CDS Planning and Development Consultancy

11th March 2026

Planning Application
44 Murray Road, Northwood, HA6 2YL
Planning Application 1787/APP/2025/1849

Please find attached the Formal Amendments for Planning Application 1787/APP/2025/1849, prepared following extensive and positive discussions with the Council across two meetings.

Second Floor Balcony Section

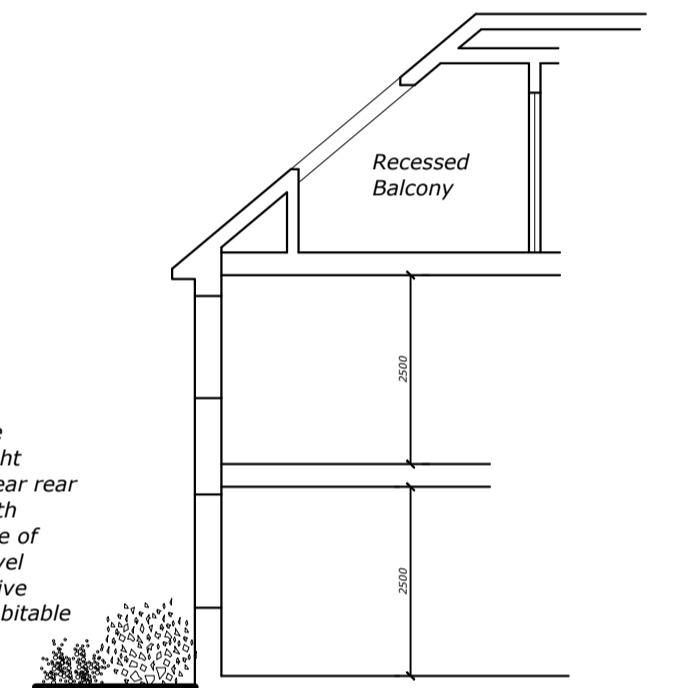
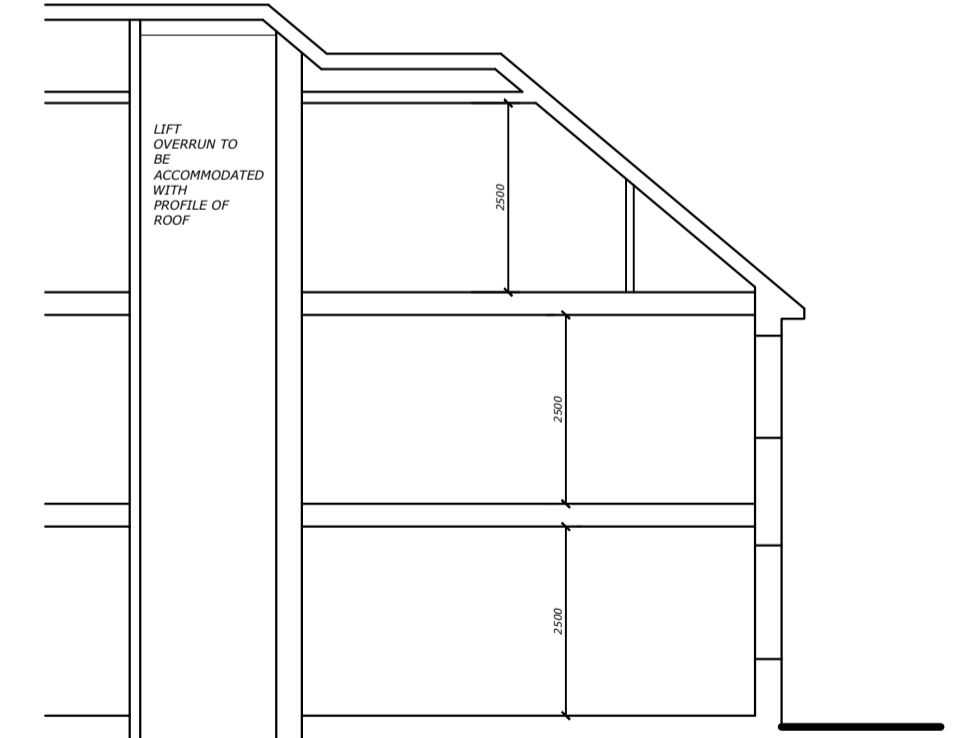
Further details were requested regarding the recessed balconies and the dormer to the rear.

Confirmation was requested regarding internal floor-to-ceiling heights.

Sections have now been provided as part of the submission to clarify these elements.

A building cross-section has now been included within the submitted drawings, demonstrating that all units would achieve an internal ceiling height of 2.5 metres, thereby complying with London Plan Policy D6.

PLAN FOR 10 No. CYCLES

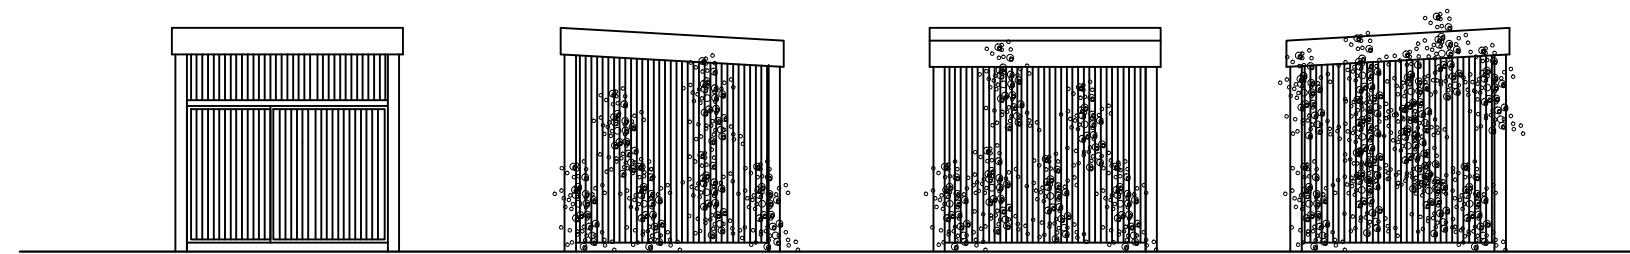
Clarification was also sought regarding the positioning of the cycle store and refuse areas adjacent to the amenity space.

Further details are now shown on the revised site plan illustrating how residents would access these facilities, together with details of the cycle store itself. Access routes would be hard landscaped to ensure usability in all weather conditions.
